**KIRKLEES METROPOLITAN COUNCIL
INVESTMENT & REGENERATION SERVICE**

DELEGATED DECISION TO DETERMINE PLANNING APPLICATIONS

Reference No:	2025/62/92833/E
Site Address:	3, Sunnybank Woods, Upper Batley, Batley, WF17 0NH
Description:	Erection of single storey front porch with associated external works
Recommending Officer:	Laura Yeadon

HOUSEHOLDER DELEGATED REPORT

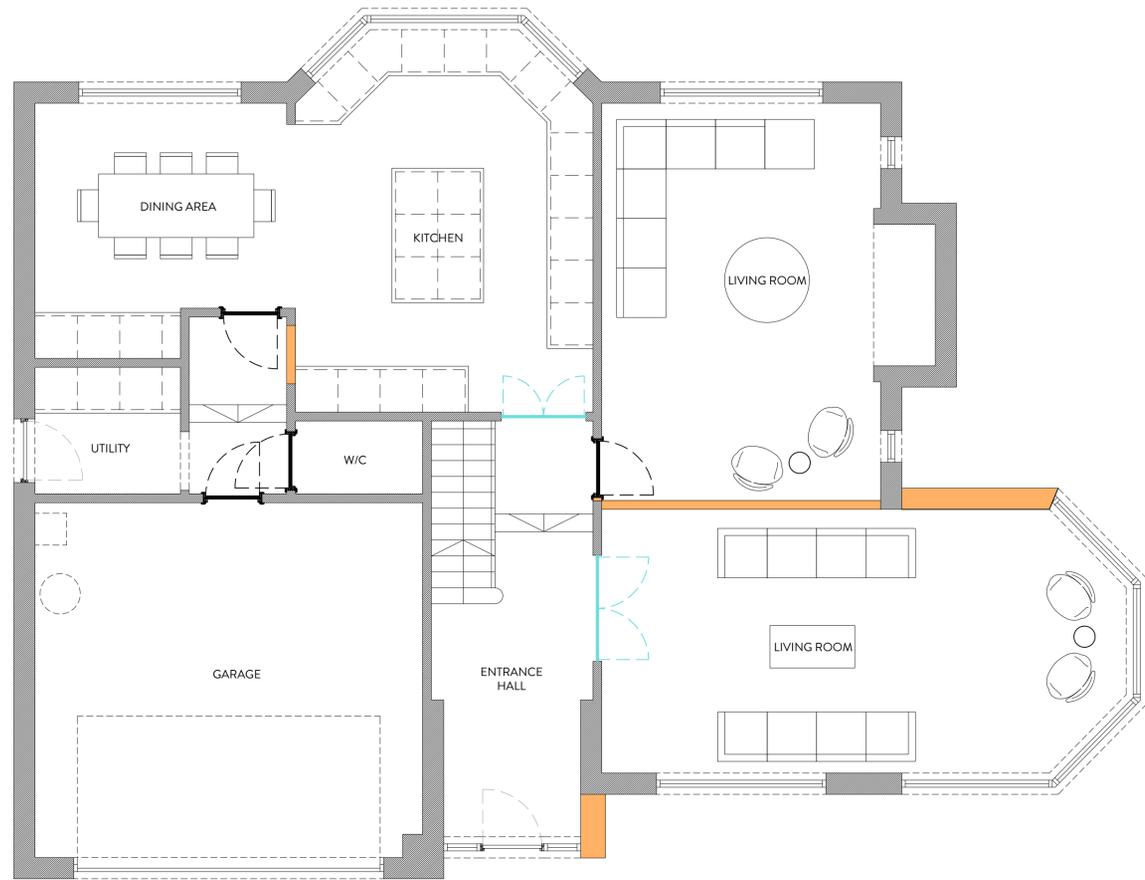
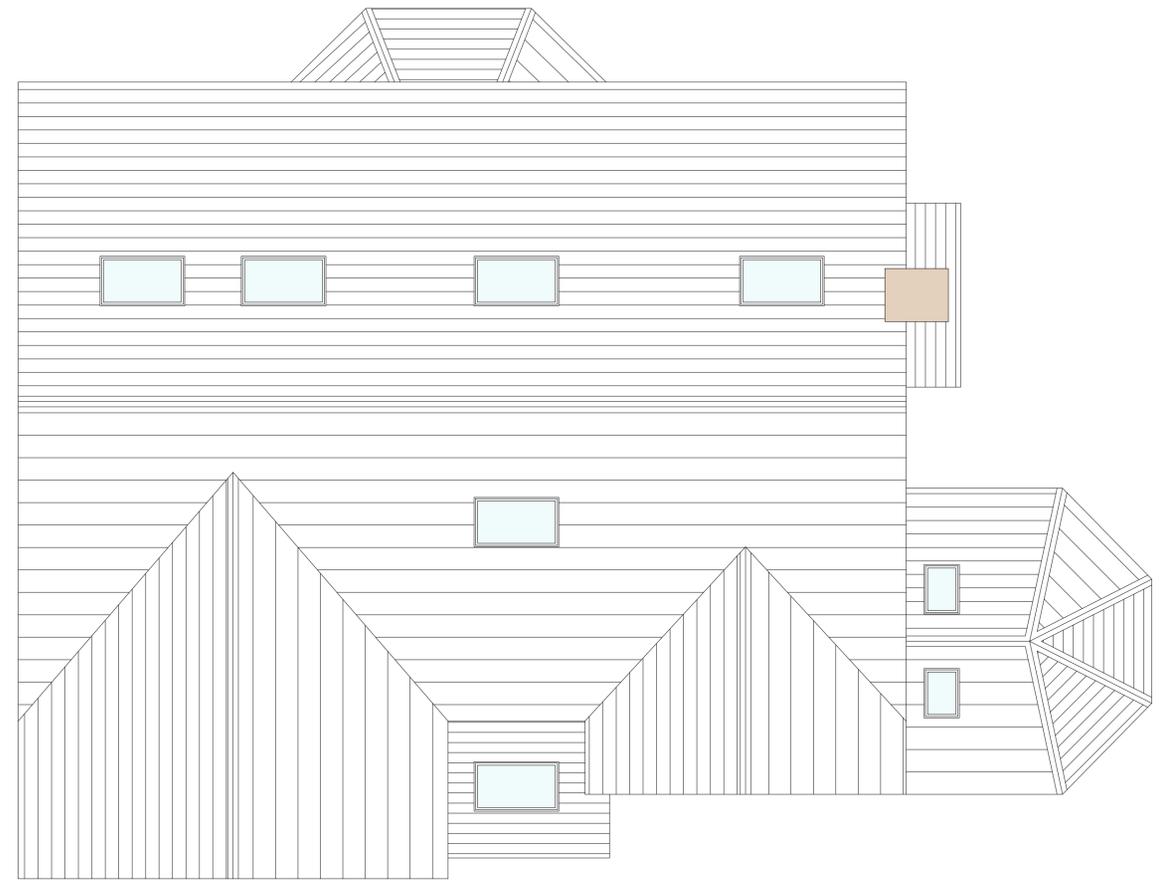
Negotiations/Amendments during course of application	Yes	The Agent amended the plans to remove the demolition of the existing conservatory and the erection of a single storey side extension. Therefore, the works to enlarge the porch remain alongside the rear wall of the conservatory being walled up
Parish/Town Council comments sought (Kirkburton)	N/A	N/A
Planning History		<p>1995/93419 – Outline application for erection of 2 no dwellings – Conditional Outline Permission</p> <p>1997/92289 – Erection of 4 no. detached four bedroom dwellings with integral garages – Conditional Full Permission</p> <p>1998/91834 – Erection of 2 detached dwellings with garages (modified proposals) – Conditional Full Permission</p> <p>2015/94056 – Works to tree(s) within a Conservation Area – part granted/part refused</p> <p>2023/92453 – Work to TPO within a Conservation Area – part granted/part refused</p>
Consultations required	None	N/A

It is proposed that the existing porch would be extended forward. The proposed front elevation would project forward of the front elevation of the living room by 0.9 metres which would be set back from the front elevation of the integral garage by 0.3 metres. The eaves height would be 2.4 metres with

an overall height of 2.9 metres to the ridge of the lean-to roof. The front and side wall of the porch would be stone with tiles for the roof.

It is proposed that the glazing within the rear elevation of the conservatory would be removed and replaced with stone walling.
